Application No: EP/115/20/PL
Site Address: 4 Beechlands Close & land rear of 18 Montpelier Road East Preston BN16 1JZ
Description of works: Side extension, loft conversion & detached garage to existing dwelling & erection of 2 No semi detached houses. This site is in CIL Zone 4 & is CIL Liable as new dwellings.

Thank you for your internet representation made on 4th November 2020 which has been recorded as an objection with the comments as follows:

DOUBLE GARAGE PLAN

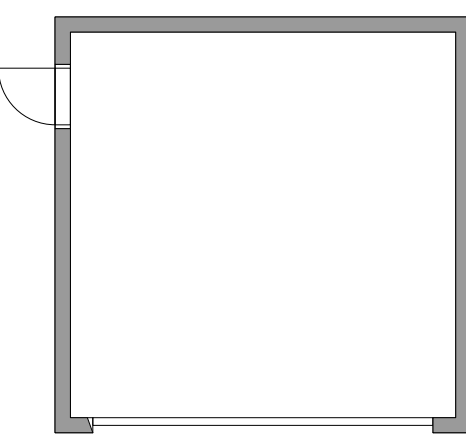
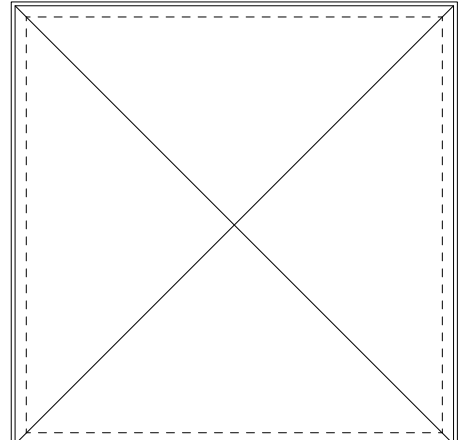
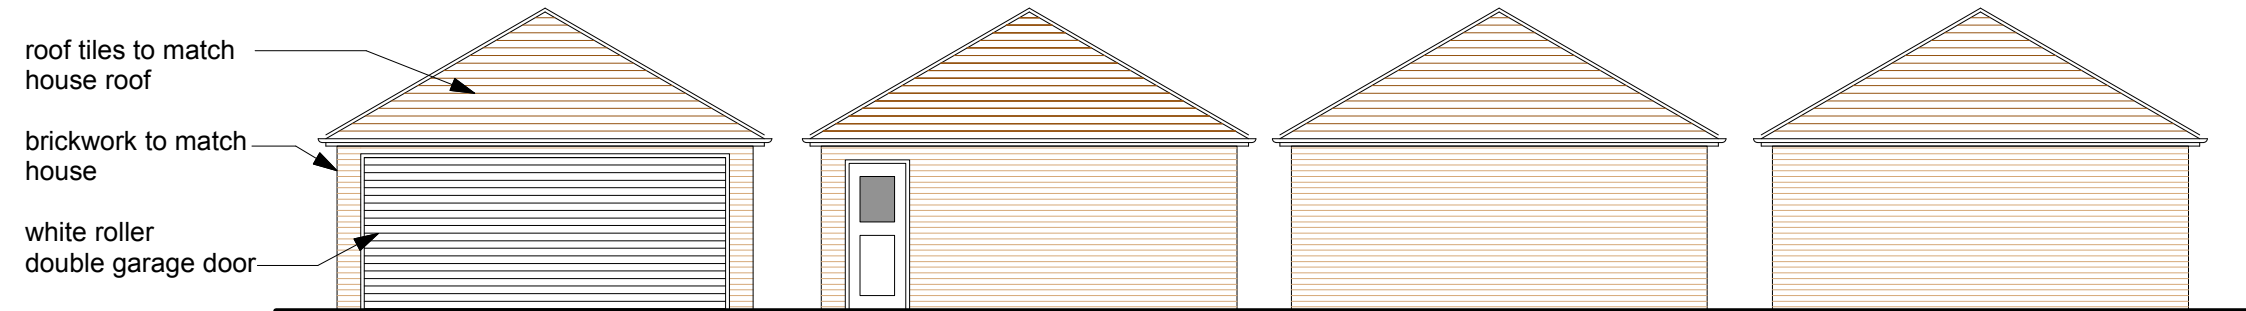
However, the proposal to place a large garage in the front garden of the bungalow is not compatible with the elementary principles of good planning, and is incompatible with Policy D DM1 of the Local Plan and Policy 1 of the Neighbourhood Plan, because it does not reflect the character of the site and the surrounding area, and does not preserve the street scene.

18 BEECHLANDS COURT, EAST PRESTON, BN16 1JZ	
Client	Description
c/o RSP ARCHITECTS LTD	NEW SEMI-DETACHED HOUSE PLANS AND ELEVATIONS

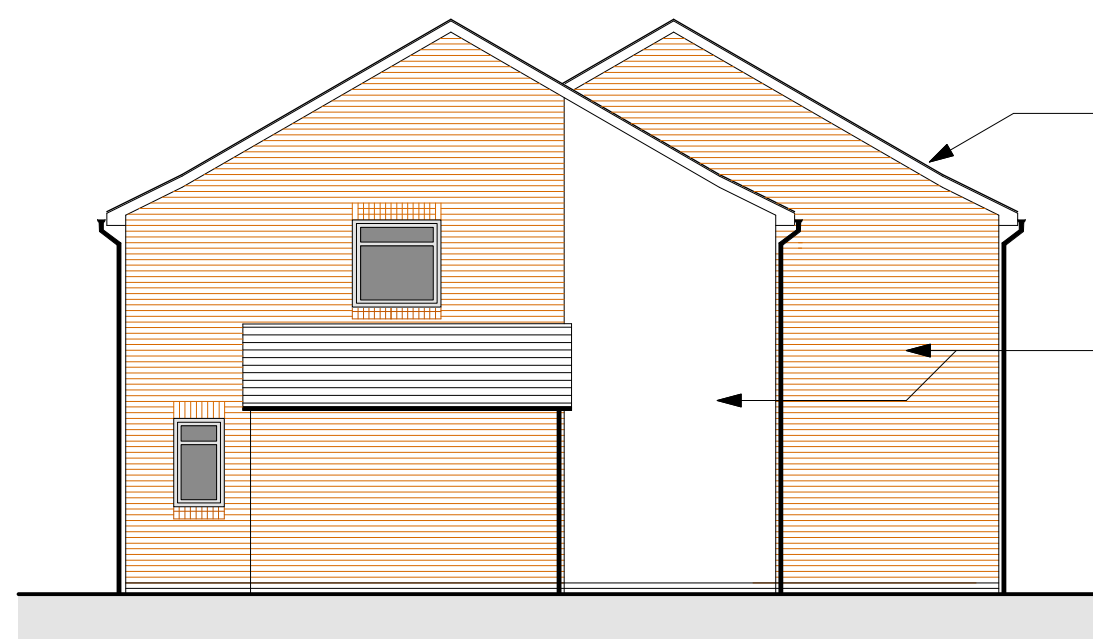
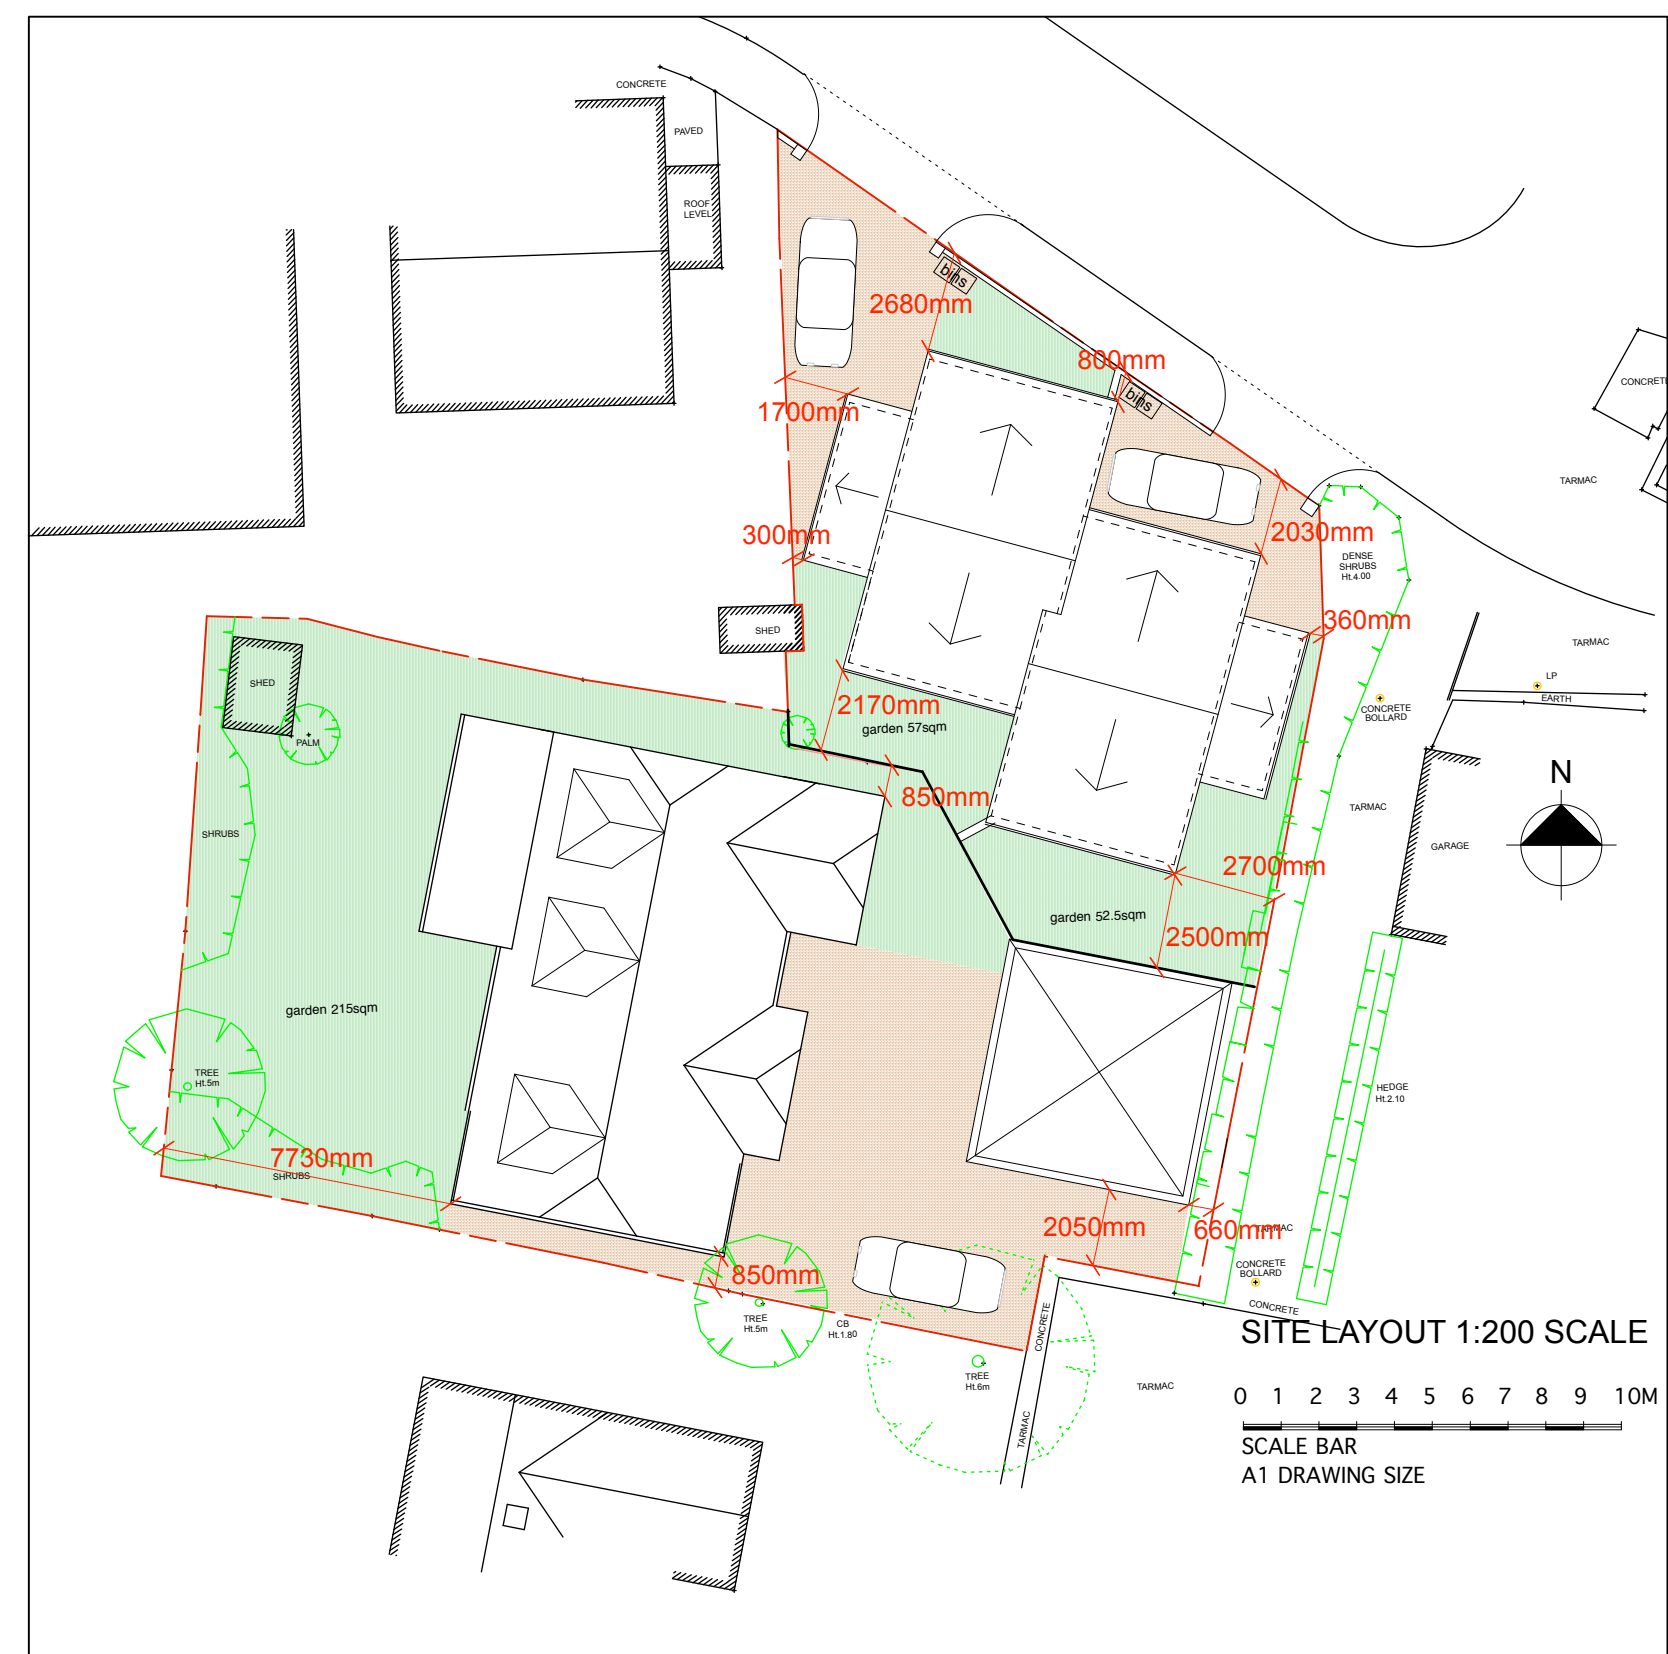
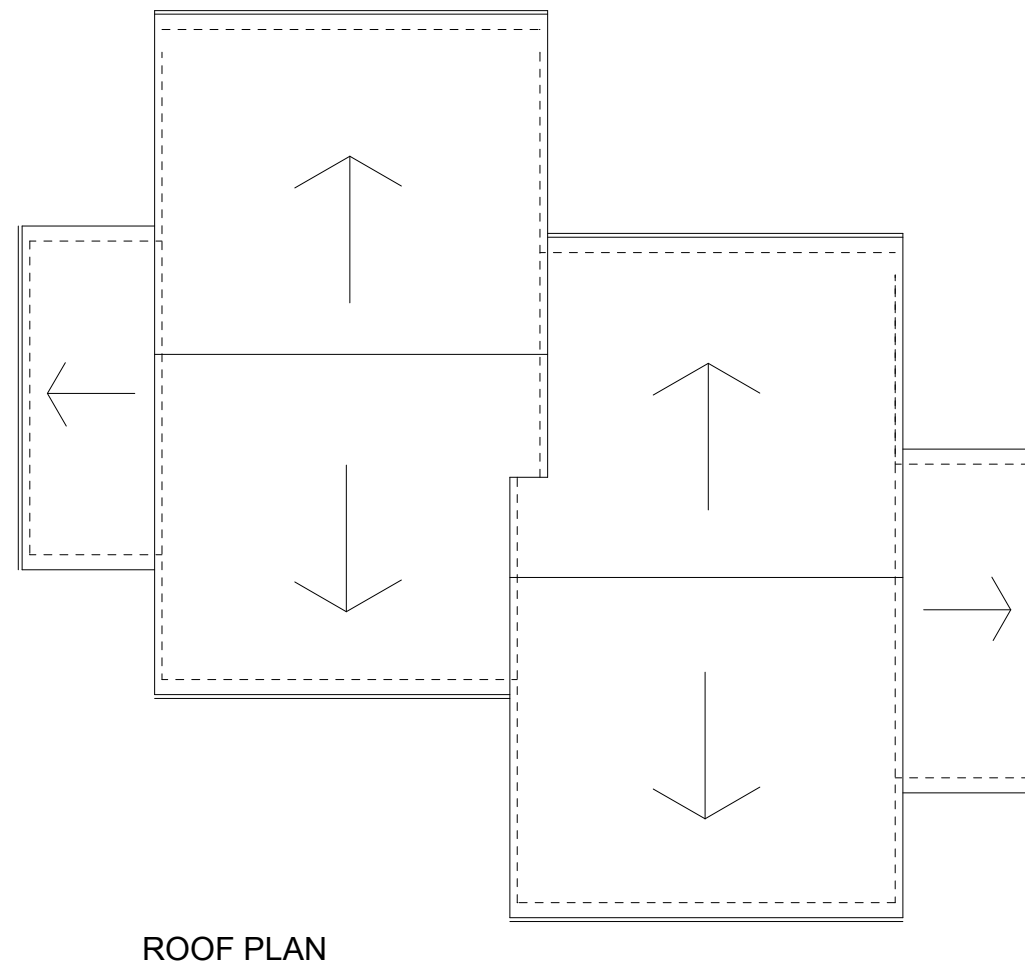
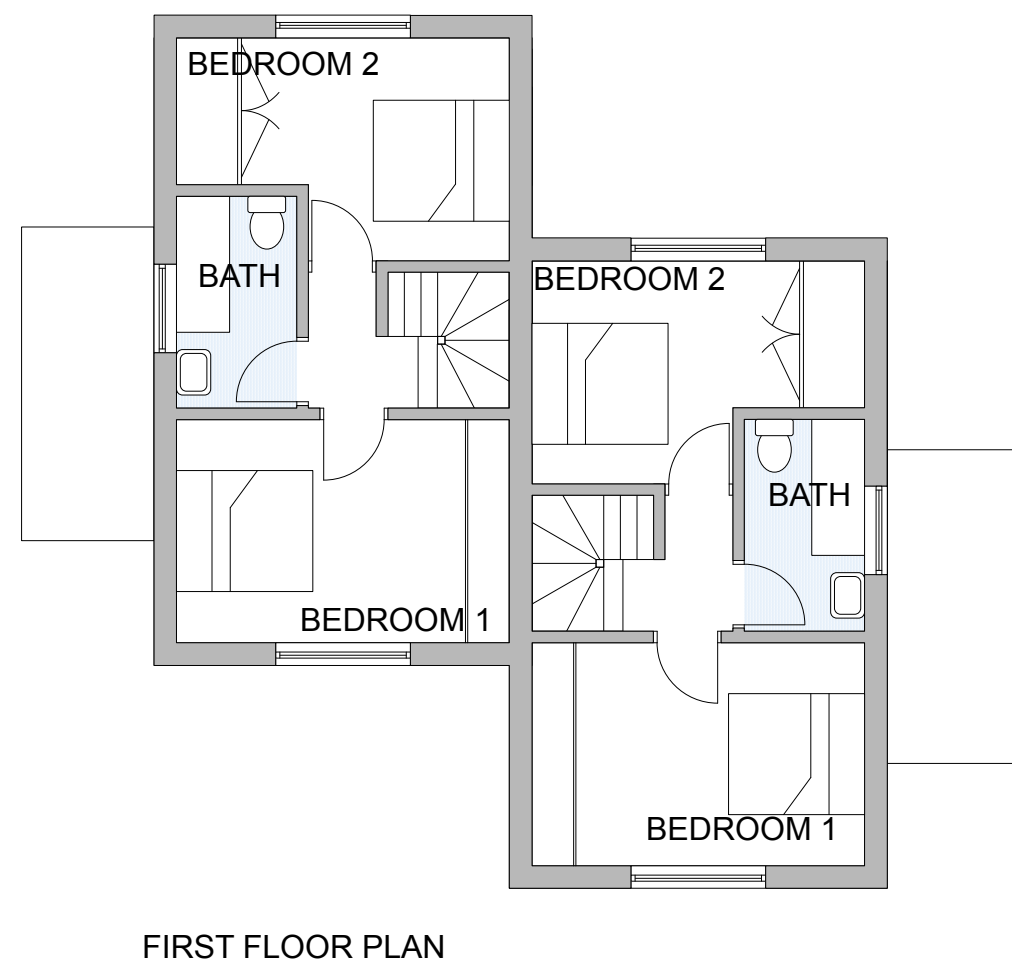
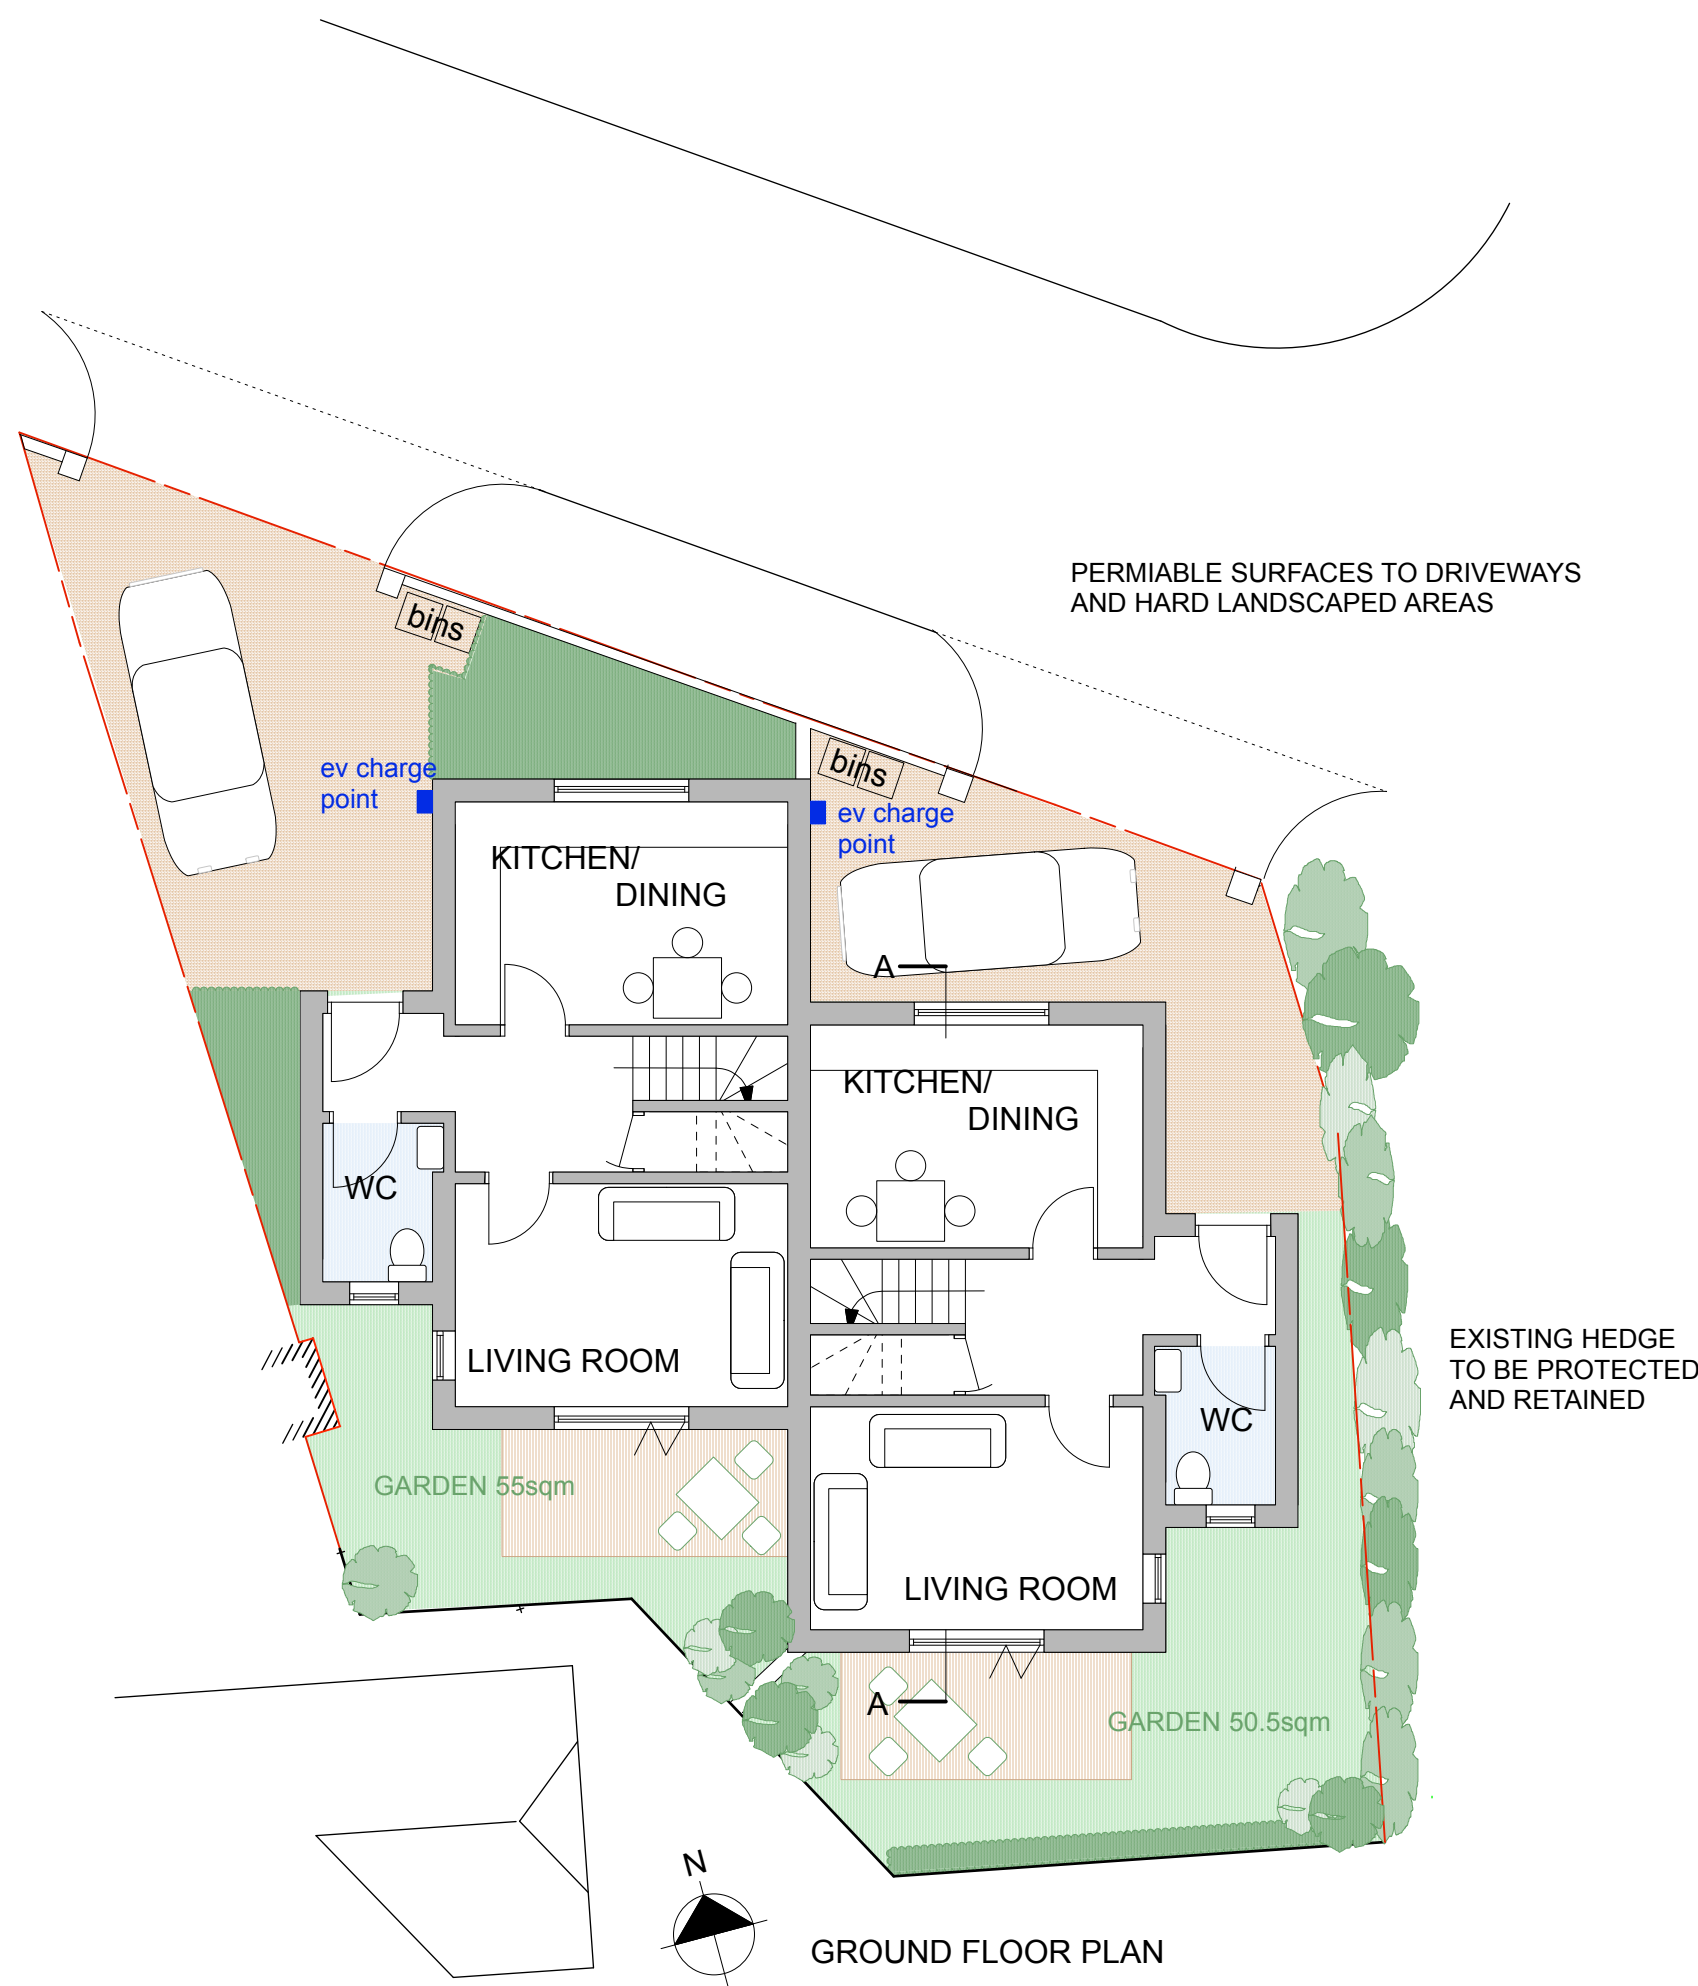
No measurements of the site of the 2 houses are supplied, but it appears to be about 200 square metres. The houses are said to be each of 70 square metres, so little space is left for a garden. There is also space for only one parking space for each house, which is inadequate for houses of this size. The Engineers report that there is no space for the soakaways needed to drain water from the roof and paving. The density of the development must be about 100 to a hectare, which is probably three or four times the level normal in the surrounding area, where bungalows set back from the road in sizeable gardens are the norm. Two storey houses are also out of character with the bungalows, and directly contravene Policy 3 of the East Preston Neighbourhood Plan. It states that a consistently low building height should be maintained, and no development should be of more than 1.5 storeys. The development also contravenes Policy D DM1 of the Local Plan, because it does not reflect the character of the area, and Policy 1 of the Neighbourhood Plan, because the scale, density and height of the houses do not reflect the character of the surrounding buildings.
